Morgan and Morecambe Offshore Wind Farm: Transmission Assets

**Appendix H3 to Natural England's Deadline 3 Submission
Natural England's comments on Onshore and Intertidal Ornithology**

Planning Inspectorate Reference EN020028

15 July 2025

**Figure 1.14: Lytham Moss BHS Mitigation Search Area (sheet 1)**

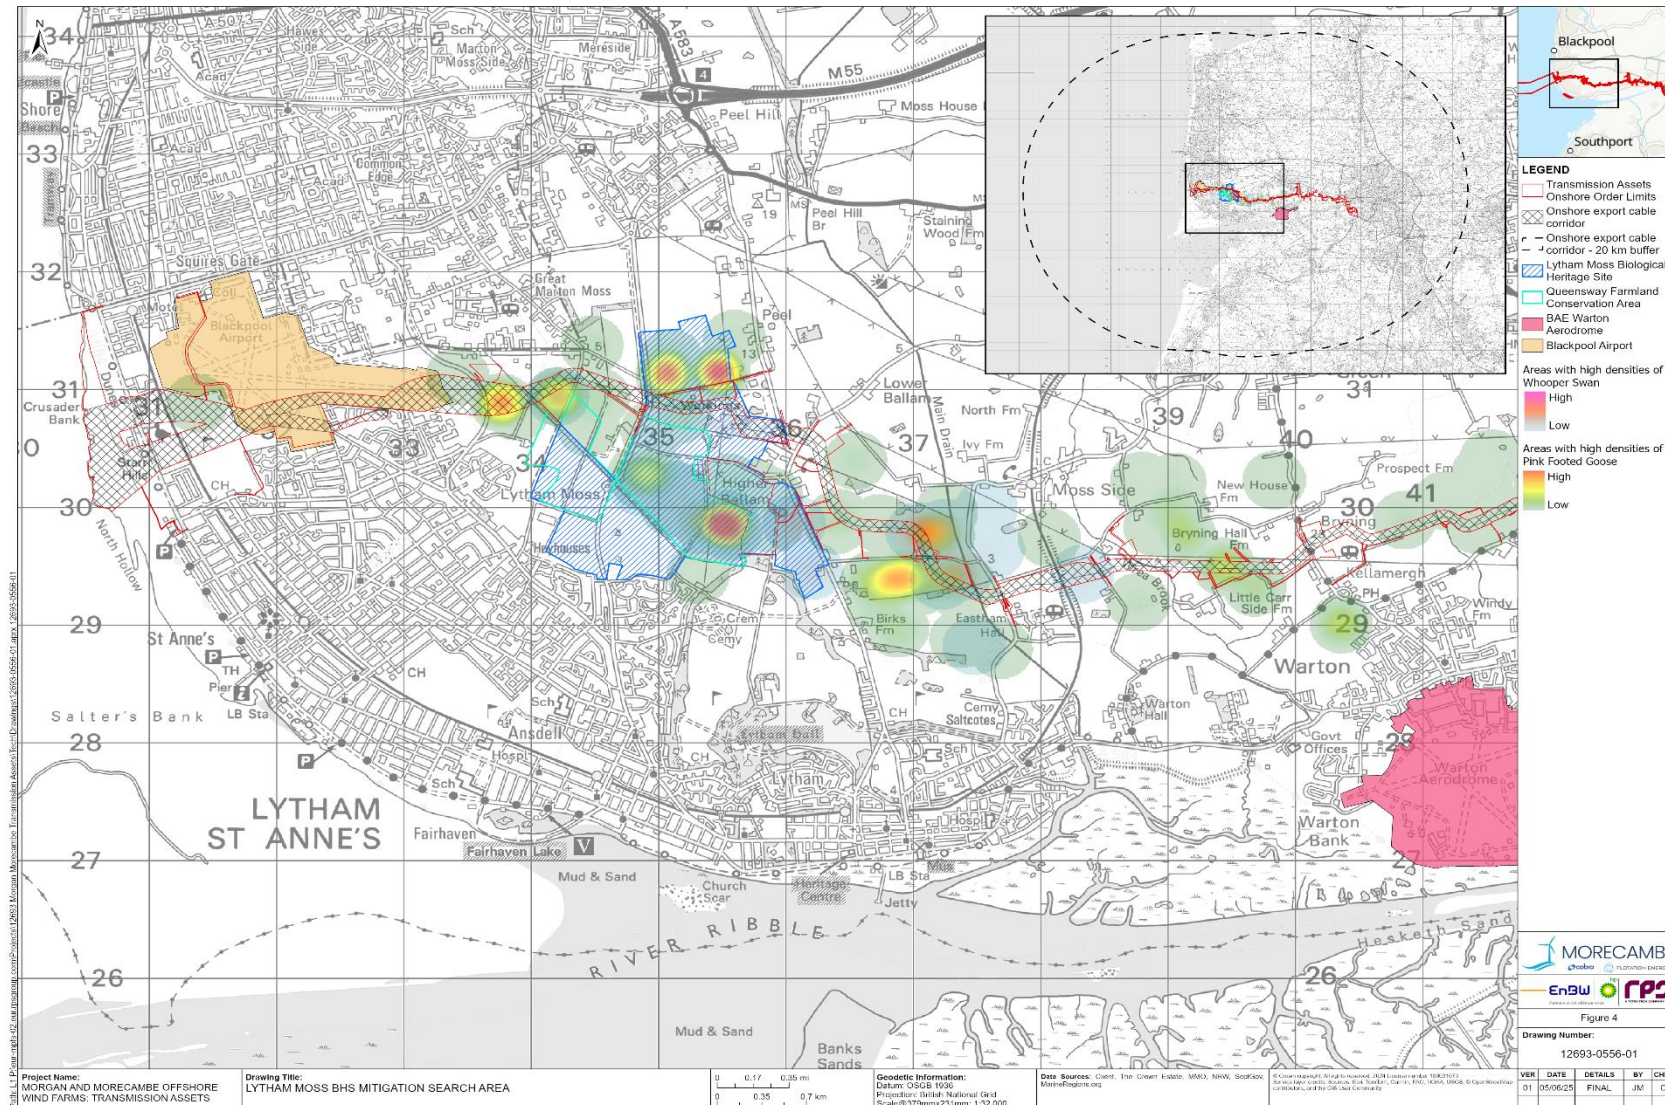
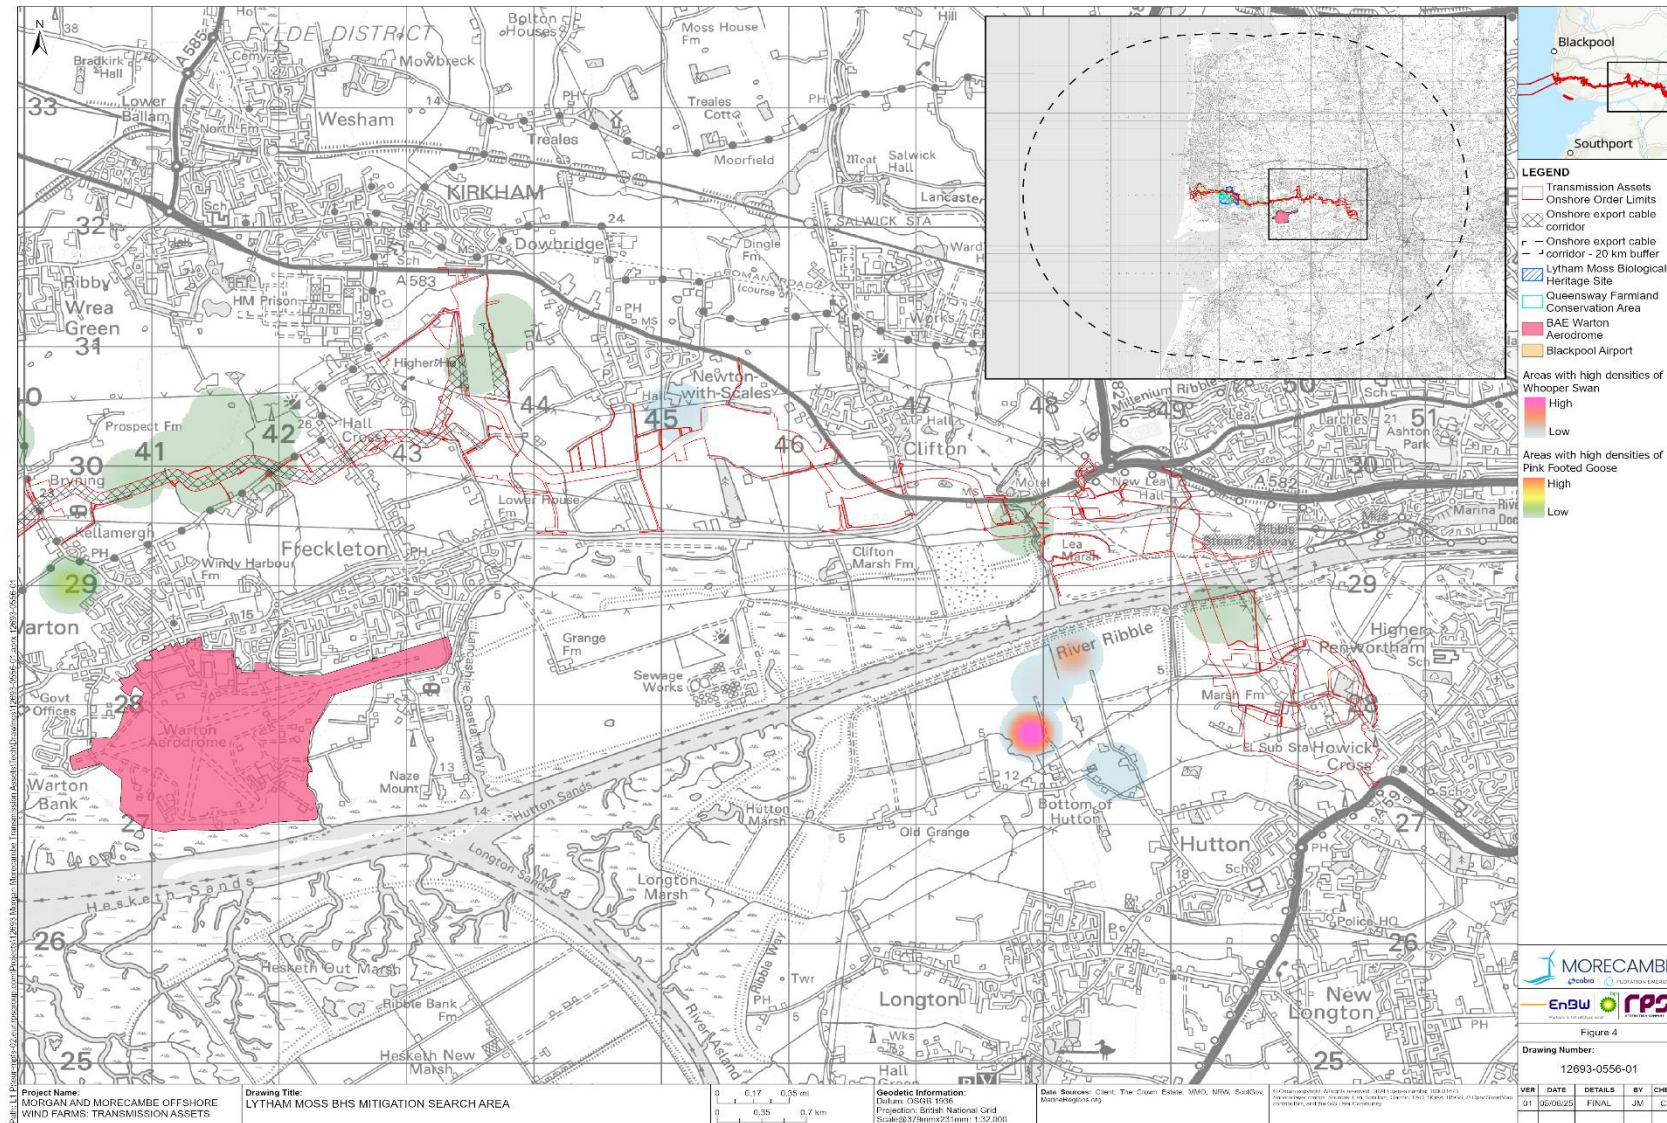
Additionally, the Lytham Moss mitigation area needs to be utilised by other displaced species occurring in numbers >1% according to baseline surveys e.g. redshank, black-tailed godwit, teal, shelduck, wigeon and golden plover (APP-017 and APP-092). There has been no detail on delivering mitigation for these species which may use the area once displaced or disturbed. These SPA/Ramsar site species have specific requirements and it cannot be assumed that measure for the prioritised species will address the impacts on these. Without detail on how mitigation habitats will cater for other species potentially impacted during construction using the cable corridor, Natural England cannot advise on suitability or be confident in the conclusions drawn in the ISAA.

3	B.2.5 – Lytham Moss (page 65)	<p><u>Supplementary Feeding</u></p> <p>Document updated which includes reference that supplementary feeding will be provided for pink-footed goose and whooper swan during core wintering period. Feeding will comprise retained spoiled crop on arable land or the import of additional feed, and will meet the calorific requirements of the affected species. The regime will be similar to that of the Farmland Conservation Area.</p> <p>Further information will be required to ensure the effectiveness of the Supplementary Feeding.</p>	<p>We advise a Supplementary Feeding Strategy will be required, which includes the following details:</p> <ul style="list-style-type: none"> • Evidence of how the timescales have been decided. The timing of the supplementary feeding should be based on the bird survey evidence on when the target birds are using the area (not just the core wintering period), and reflect likely rates of consumption; • If the applicant chooses to import additional feed, then the grain calculations should be included within the strategy to ensure its efficiency. These should be based on the calorific requirements of the effected species;

<ul style="list-style-type: none"> Clarification of when the supplementary feeding will start. NE advise any supplementary feeding should be instigated in the November of the year that the construction of the proposed development commences, or earlier if the bird evidence shows the birds are utilising the area earlier e.g. September or October; Details of the monitoring that will be undertaken to ensure the supplementary feeding is effective, and to ensure adequate measures will be in place; and The length of time that the supplementary feeding will be in place.
		<p><u>Creation of Scrapes</u></p> <p>We acknowledge the detail included on the creation of scrapes; however further information is required to ensure the scrapes will be maintained and monitored.</p>	<p>We advise the Applicant to include subsequent detail in a draft Habitat Management Plan:</p> <ul style="list-style-type: none"> Managing water levels to maintain it at a suitable level; Species specific measures to ensure the scrapes provide suitable habitat (with a focus on species occurring >1%); and Grassland management in surrounding areas: sward height, mowing/grazing schedule to maintain surrounding area at an optimal time for the months proposed.

Figure 1-1: Environmental mitigation areas at south of Newton-with-Scales

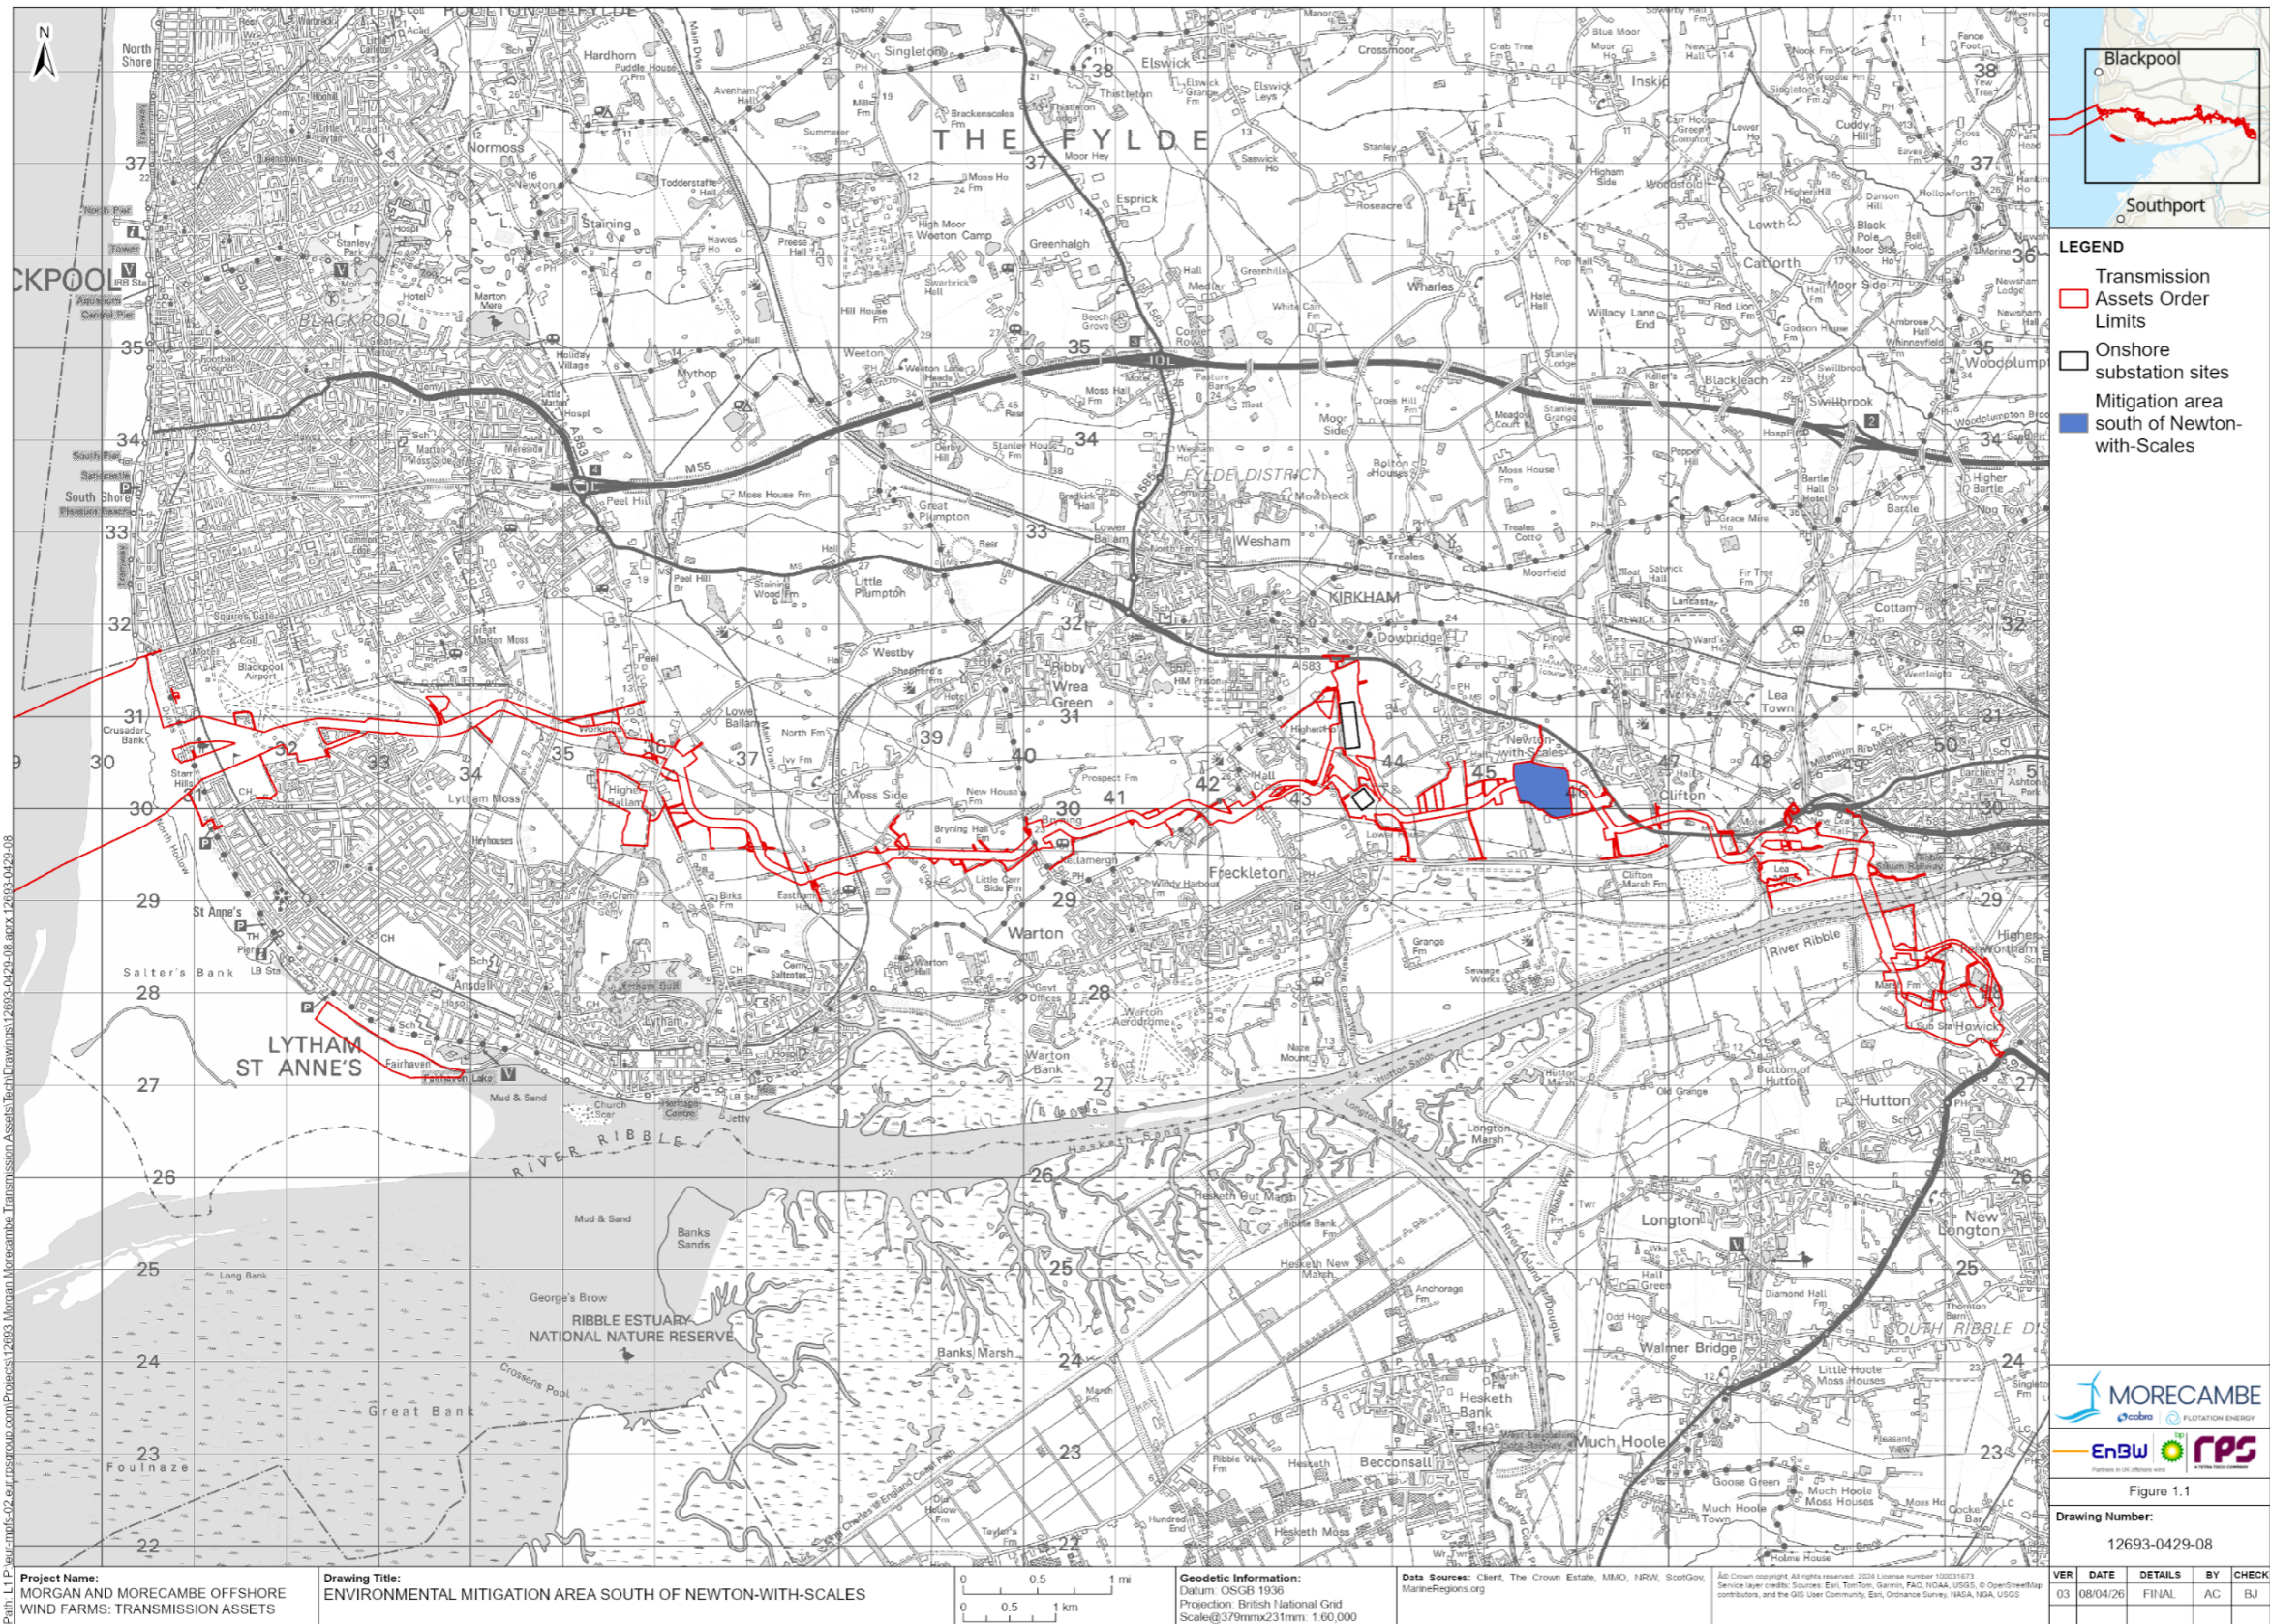
We consider that the permanent mitigation area at Newton-with-Scales has the potential to support the mitigation need. We acknowledge the additional information provided within the OEMP [REP2-019], which does include specific details on creation of scrapes suitable for waders and wildfowl and re-wetting areas by installing sluices. The measures and indicative locations of the mitigation measures are potentially appropriate for the birds likely to require alternative habitat; however we advise that further detail is still required and greater consideration of its suitability on a species-by-species basis. Specifically, as mentioned for the other mitigation areas, information is needed on how the site will be delivered and how the desired habitats will be achieved at an appropriate scale. Both these aspects of the mitigation area were discussed on the site visit on 28th April 2025.

It remains our position that for both the mitigation areas (Lytham Moss and Newton-with-Scales) there is insufficient detail on how these sites will effectively support the FLL for displaced and disturbed species and how these mitigation areas will effectively be delivered. Additionally, there has been minimal consideration of the extent to which the areas will deliver for the birds that are currently using these mitigation areas, in addition to the birds potentially displaced and/or disturbed which could also use the areas during the construction period. Further detail is therefore required to show how the birds impacted by the development will be supported in addition to birds already using the areas.

Therefore, we advise that the Applicant should produce detailed draft Habitat Management Plans for the mitigation areas which should include detail on the measures, their relevance to specific waterbirds species, how these measures will be delivered, timescales of delivery and monitoring to demonstrate the measures are appropriate and inform adaptive management if needed. For each mitigation area suggested measures that could be included are discussed in Table 1.

4	B2.2 Land to the south of Newton-with-Scales (page 58)	<p>The area is proposed to be suitable to mitigate for non-breeding waders, breeding waders, wildfowl, and farmland birds and non-breeding wildfowl and farmland birds.</p> <p>The site is therefore going to be delivering for the needs of multiple different species and there is lack of detail of how this will be achieved.</p>	<p>More detail is needed on measures for each group of birds and how these will be developed. This should be outlined in a detailed draft Habitat Management Plan. The plan should also include detail on monitoring the measures and commit to adaptive management on the basis of monitoring findings.</p>
		<p><u>Wet Features</u></p>	<p>The draft Habitat Management Plan should include additional detail outlining how rewetting will be achieved and monitored.</p>

There is no detail on where the sluices will be installed, target water levels and whether rewetting of the site will be monitored.	
		<p><u>Creation of scrapes</u></p> <p>There is a map showing the indicative locations of the scrapes and some detail on the location and size of the scrapes; however further detail is required to ensure the scrapes will be appropriately maintained.</p>	<p>We advise the Applicant to include subsequent detail in a draft Habitat Management Plan:</p> <ul style="list-style-type: none"> • Managing water level to maintain it at a suitable level and how this will be achieved; and • How the habitat will be designed to cater for species specific requirements
		<p><u>Grassland management</u></p> <p>More detail is needed on how the mosaic of grassland will be delivered and maintained.</p>	<p>We advise the Applicant to include further detail in a draft Habitat Management Plan:</p> <ul style="list-style-type: none"> • Management regarding proposed sward height/s, approach to mowing/grazing to maintain area in optimal conditions for the months proposed, taking into account species-specific requirements; • Percentage of area for each grassland habitat to ensure the breeding and non-breeding birds will be supported by each area of varying height; • Indicative annual timings of grassland management; • Detail on predator management proposed for ground-nesting birds; and • Monitoring schedule to allow for adaptive management of the site as required.

<p><u>Field Margins</u></p> <p>More detail is required on the measures to improve the existing field margins.</p>	<p>We advise the Applicant to include further detail in a draft Habitat Management Plan:</p> <ul style="list-style-type: none"> • Information to show where the tall grasses and wildflower areas will be situated in relation to the other grassland habitats and scrapes;

<ul style="list-style-type: none"> • Outline plan of planting hedgerows; and • More detail on changes to the cutting regime and 'gapping up' e.g. across all the field margins or certain sections and timings of cutting.
--	--	--	--
